CITY OF ALBUQUERQUE

Re: Touro College of Dental Medicine/ Tenant Improvements
2425 Ridgecrest Dr. SE
Traffic Circulation Layout
Architect's Stamp 04-10-24 (M18-D006)

Based upon the information provided in your submittal received 04-15-24, the above referenced plan cannot be approved for Building Permit until the following comments are addressed:

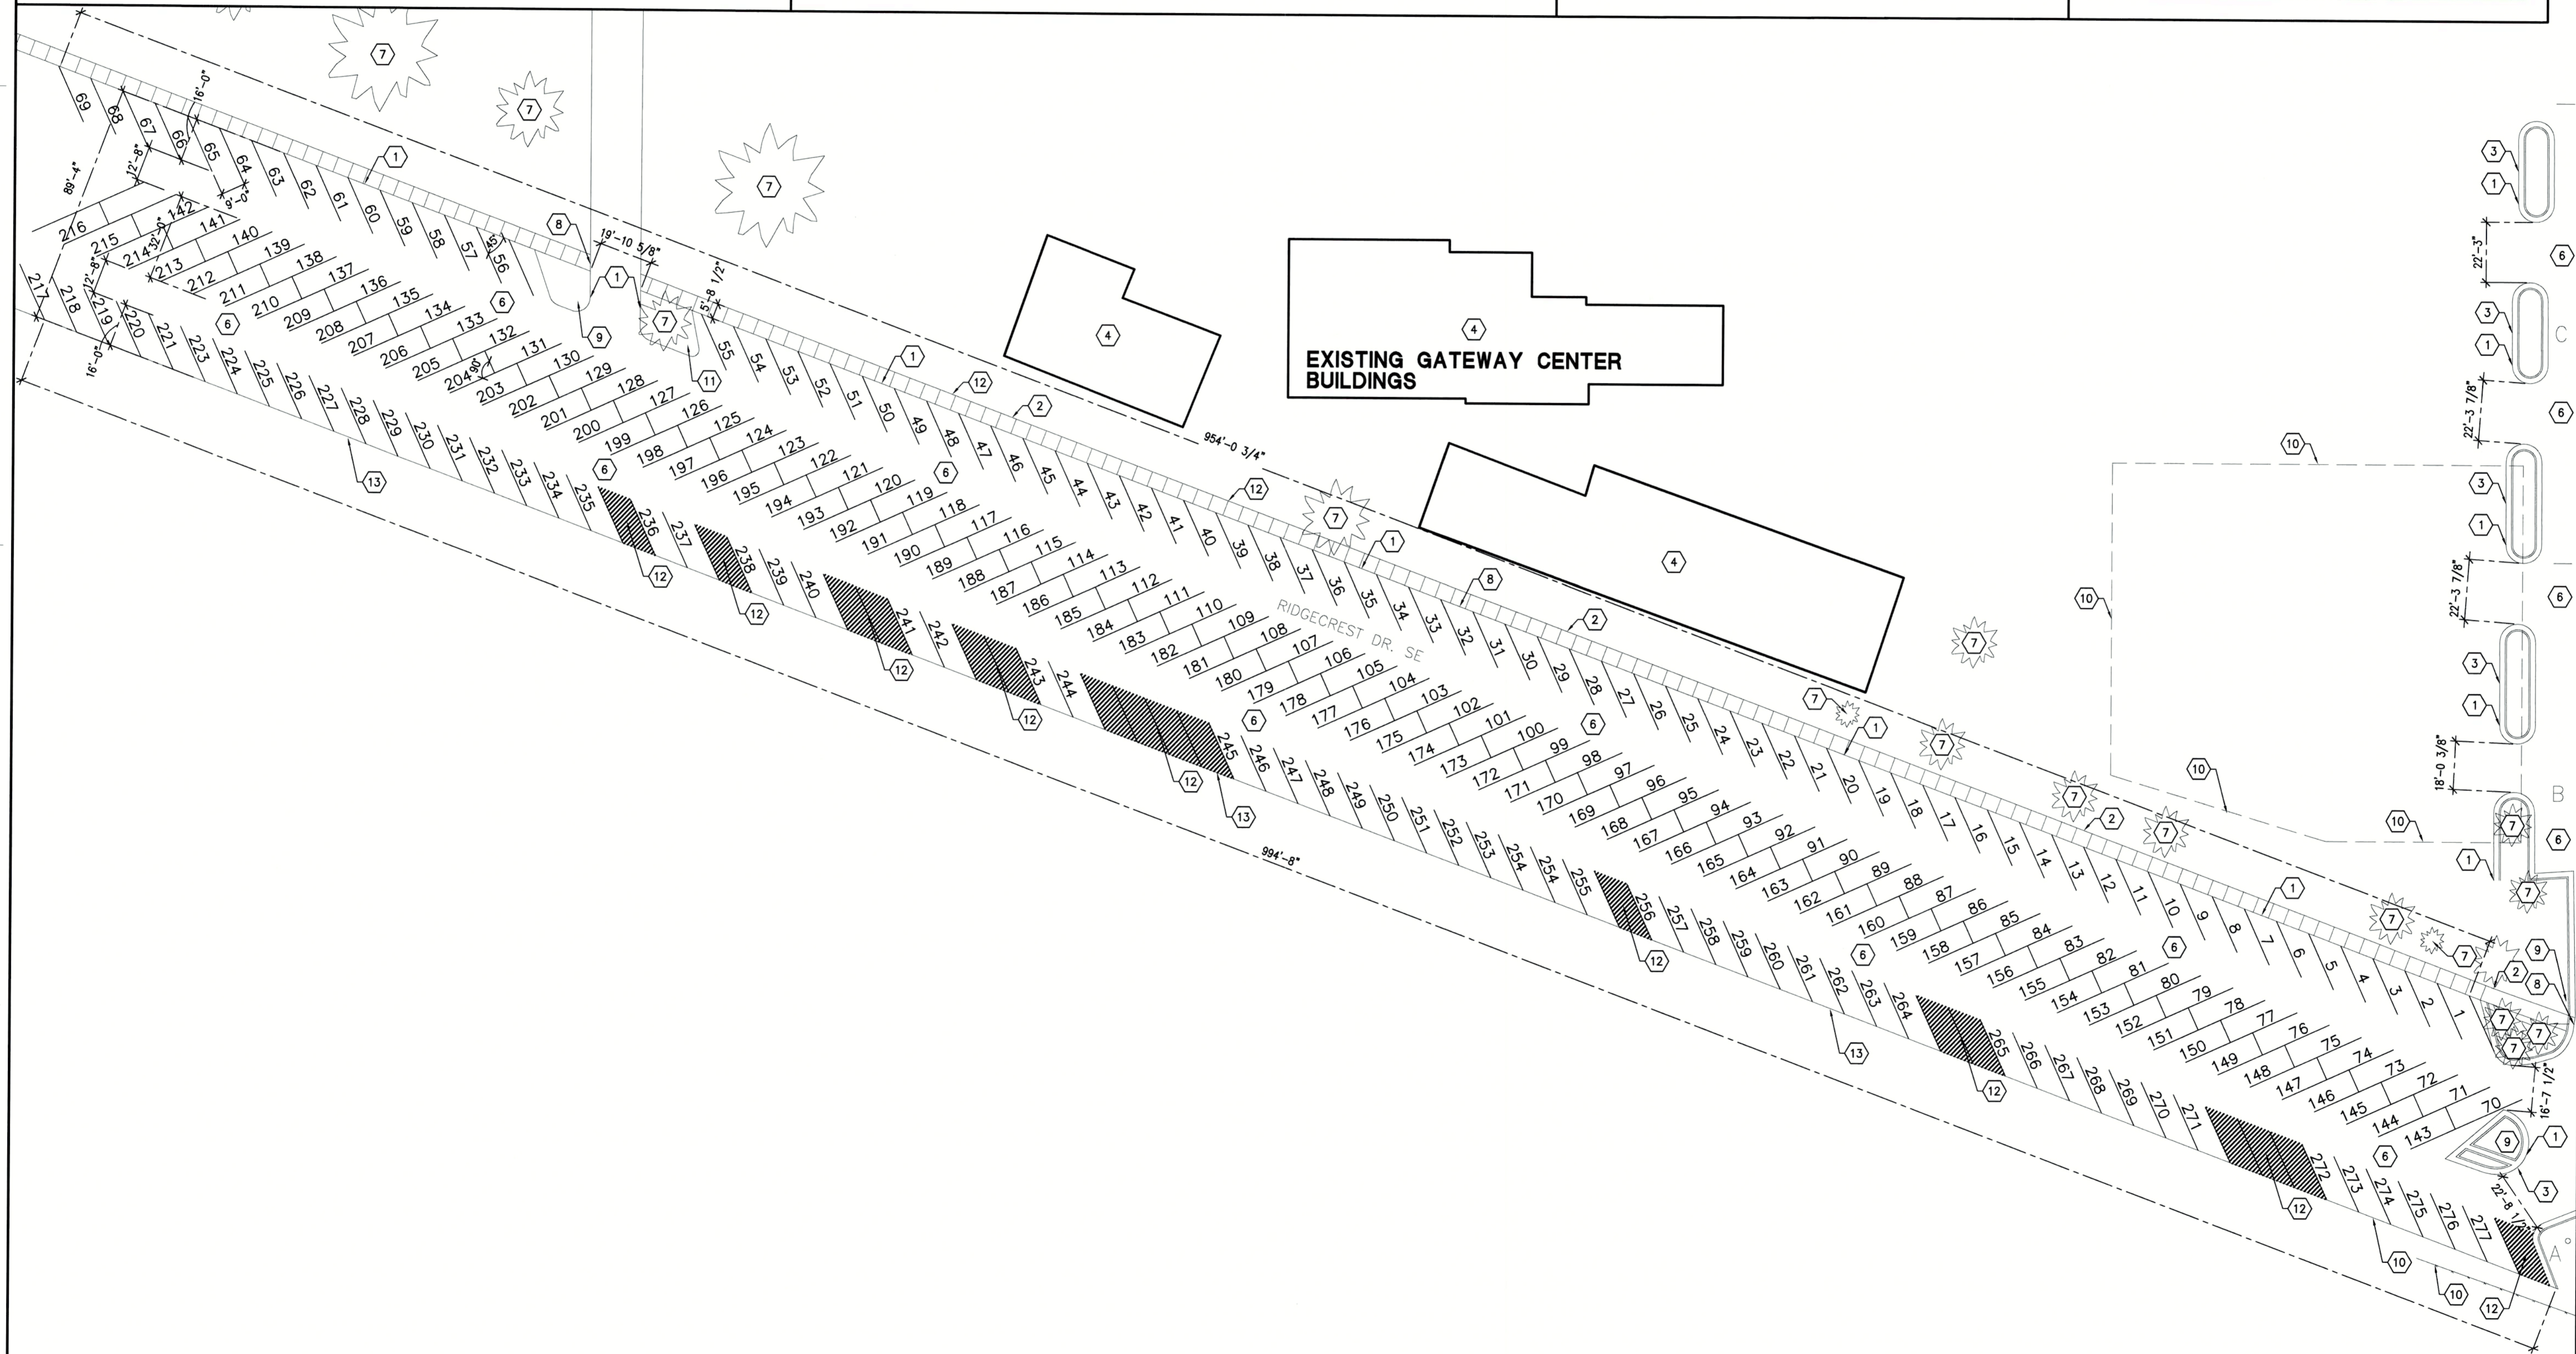
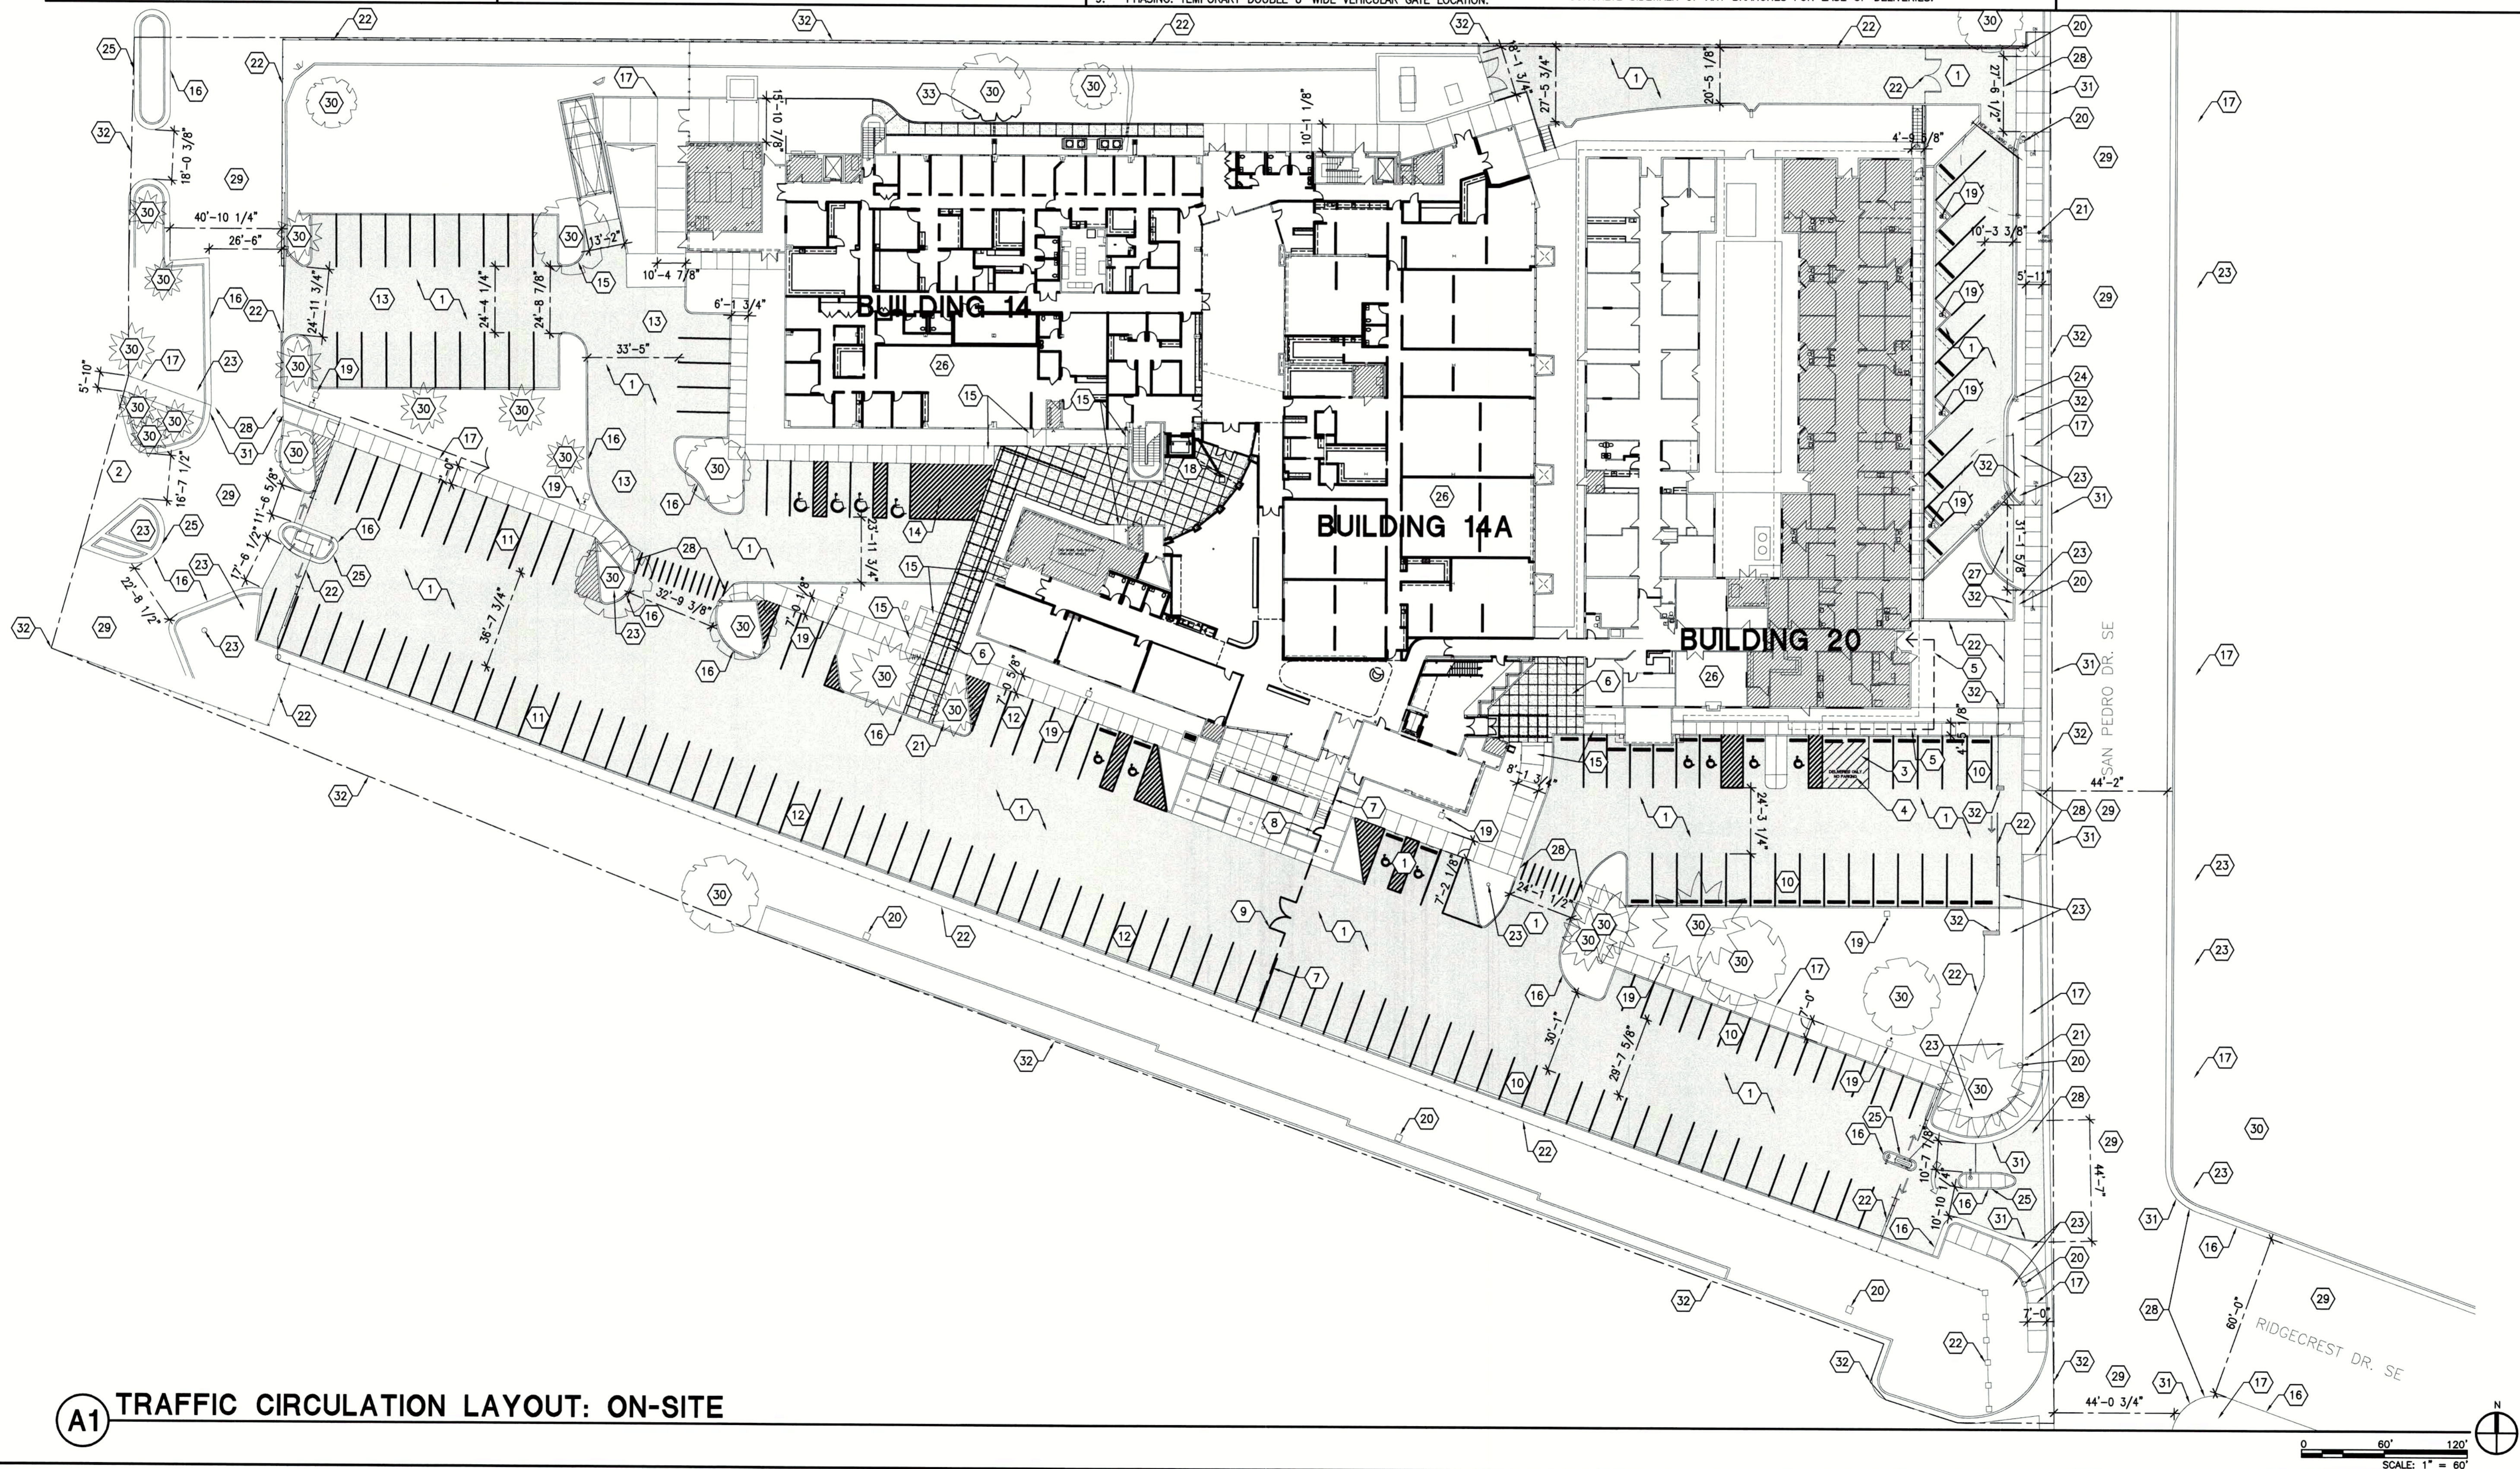
1. List the number of Motorcycle and Bicycle parking spaces required by the IDO.
 - Number of Motorcycle Spaces Required: 6 spaces, per 301-500 Required Off-street Vehicle Parking Spaces. Motorcycle parking locations indicated on drawing.

2. Identify the right of way width, medians, curb cuts, and street widths on San Pedro Dr. SE.
 - Yes. Have revised TCL to include comment.
3. All site accesses off San Pedro Dr. must be updated to current ADA standard and have Truncated Domes installed.

- Yes. Have revised TCL to include comment.
4. Please clarify: is this existing curb cut will be utilized? If yes, it must be updated as mentioned in the previous comment. If no, Unused curb cuts must be replaced with sidewalk and curb & gutter. A build note must be provided referring to the appropriate City Standard drawing.

5. Please list the width and length for all existing and proposed parking spaces. Some dimensions are not shown.

7. The ADA accessible spaces must include an access aisle. Van accessible aisles should be 8ft wide; all others should be 5ft wide.

8. The ADA accessible parking sign must have the required language per 66-7-352.4C NMSA 1978 **"Violators Are Subject to a Fine and/or Towing."** Please call out detail and location of signs.

9. The ADA access aisles shall have the words **"NO PARKING"** in capital letters, each of which shall be at least one foot high and at least two inches wide, placed at the rear of the parking space so as to be close to where an adjacent vehicle's rear tire would be placed. (66-1-4.1. B NMSA 1978)

10. All interior and exterior ADA curb ramps must be updated to current standards and have truncated domes installed.

11. Motorcycle parking spaces shall be designated by its own conspicuously posted upright sign, either free-standing or wall mounted per the zoning code.

12. The pavement marking "MC" should be shown in the opposite direction for motorcycles entering the parking space.

15. A 1-foot clear zone around the bicycle parking stall shall be provided.
 - Yes. Have revised TCL to include comment.
16. Bicycle parking spaces shall be at least 6 feet long and 2 feet wide.

- Yes. Have revised TCL to include comment.
17. A 5 ft. keyway is required for dead-end parking aisles.
 - Yes. Have revised TCL to include comment.
18. Per the IDO, a 6 ft. wide ADA accessible pedestrian pathway is required from the public sidewalk to the building entrances. Please clearly show this pathway and provide details.

- Yes. Have revised TCL to include comment.
23. Please provide a sight distance exhibit
 - Yes. Have revised TCL to include comment.
24. Show the clear sight triangle and add the following note to the plan: "Landscaping and signage will not interfere with clear sight requirements. Therefore, signs, walls, trees, and shrubbery between 3 and 8 feet tall (as measured from the gutter pan) will not be acceptable in the clear sight triangle."

26. Key note 17 in sheet TCL-101 and keynote 2 in sheet TCL-102: Add a note stating "All broken or cracked sidewalk must be replaced with sidewalk and curb & gutter." A build note must be provided referring to the appropriate City Standard drawing.

- Yes. Have revised TCL to include comment.

- Yes. Have revised TCL to include comment.

- Yes. Have revised TCL to include comment.

- Yes. Have revised TCL to include comment.

- Yes. Have revised TCL to include comment.

- Yes. Have revised TCL to include comment.

- Yes. Have revised TCL to include comment.

- Yes. Have revised TCL to include comment.

- Yes. Have revised TCL to include comment.
25. Please specify the City Standard Drawing Number when applicable.
 - Yes. Have revised TCL to include comment.

- Yes. Have revised TCL to include comment.
